OXFORDSHIRE COUNTY COUNCIL'S RESPONSE TO CONSULTATION ON THE FOLLOWING DEVELOPMENT PROPOSAL

Application no: 23/03073/HYBRID

Proposal: In FULL, the construction of an 82-apartment affordable extra care home (C2 use class) with associated openspace / green infrastructure, landscaping, car / cycle parking, service infrastructure (drainage, highways, lighting), engineering operations, creation of new vehicular access and re-instatement of existing access to footpath, and in OUTLINE, the construction of up to 14 residential (C3 use class) dwellings with associated landscaping, service infrastructure (highways, drainage, lighting)

Location: Phase 2 SW Bicester Kingsmere Parcel R East Of, Ludlow Road, Bicester

2.4m x 43m Visibility Splays

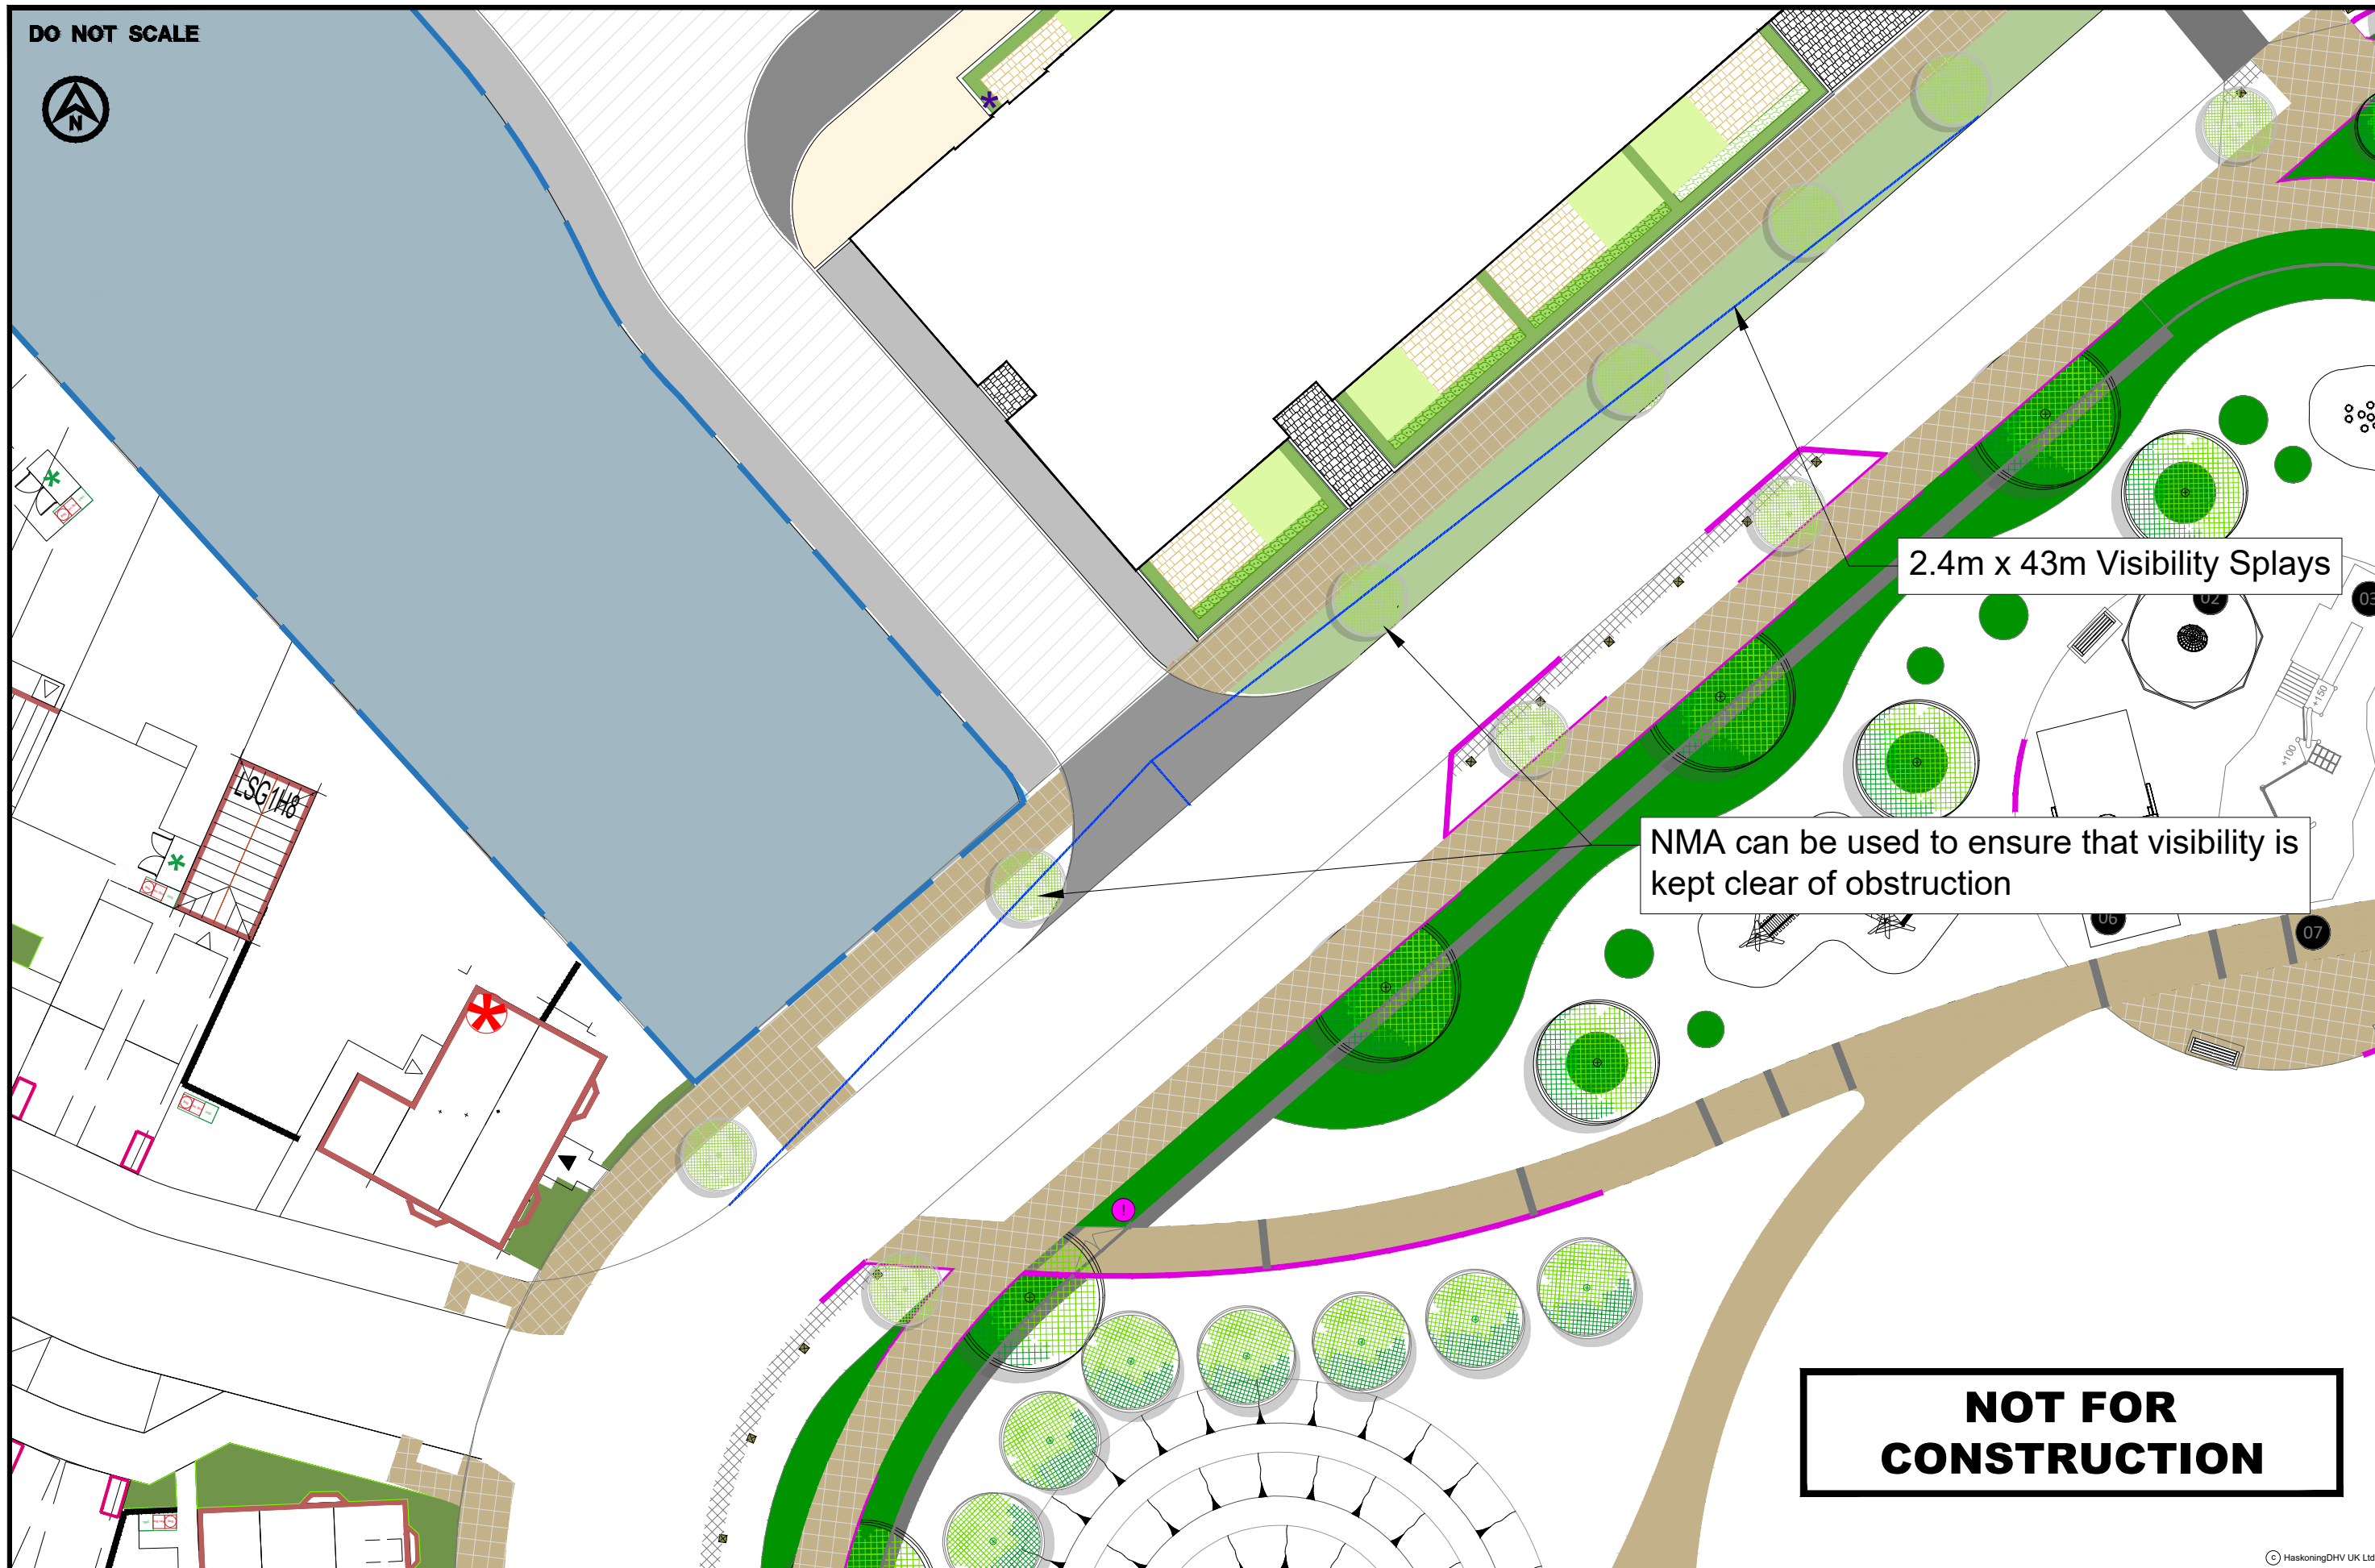
- Although the required safe visibility splays appear to be contained within the public highway there appears to be possible obstructions within it (e.g. shrubs / wall). The visibility splay should be free of obstructions 2m high down to a point 600mm above the carriageway.

Insert 1.1 Site Location

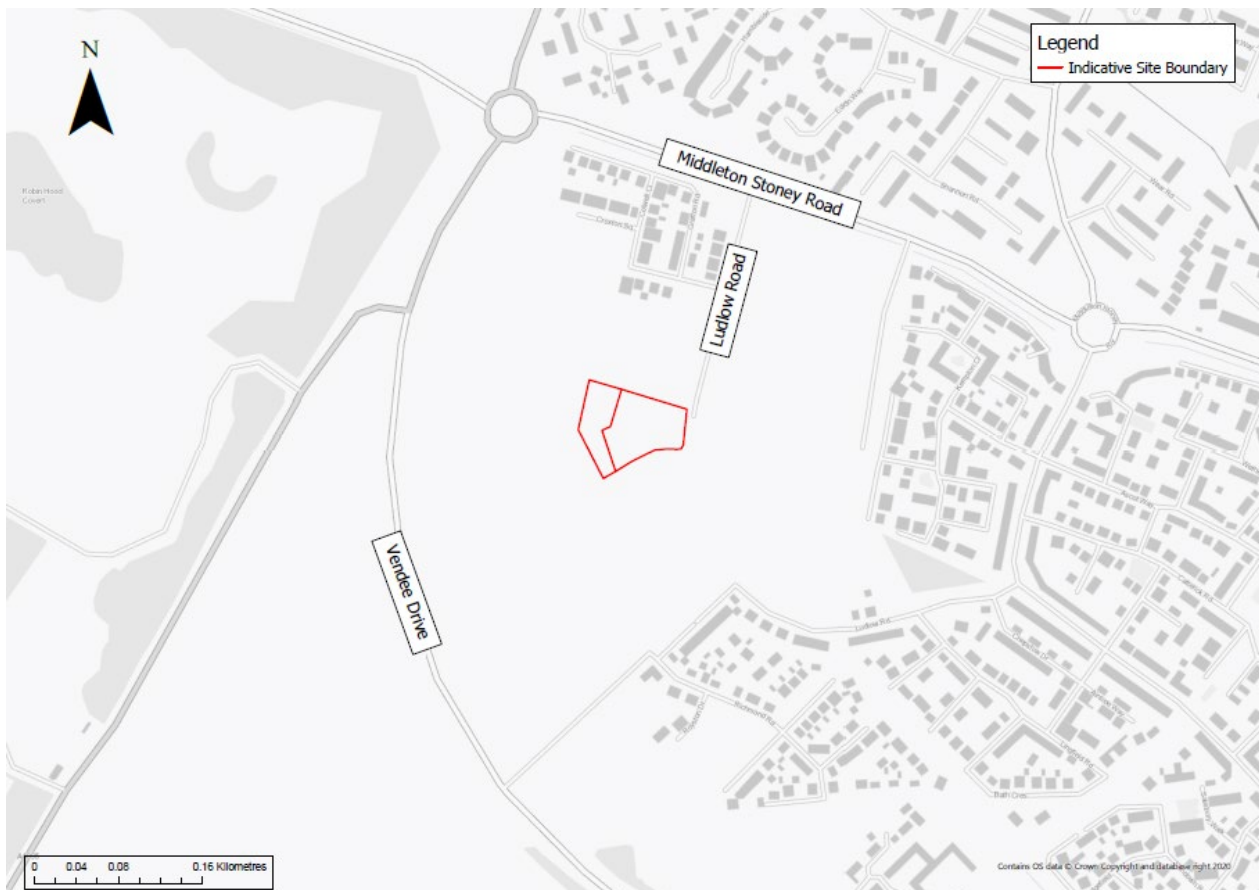
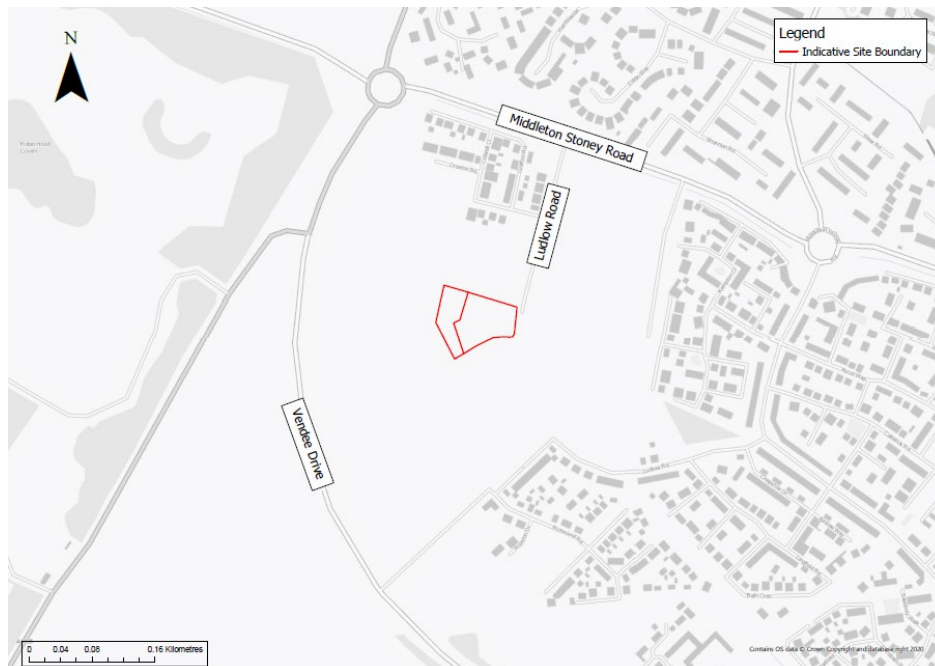
- What is the expected date of occupation?
- Paragraph 1.1.3. The Travel Plan should be a standalone document. Whilst it is fairly easy to refer to additional document during the planning process, accessing this information can be problematic for the Travel Plan Co-ordinator at a later date.
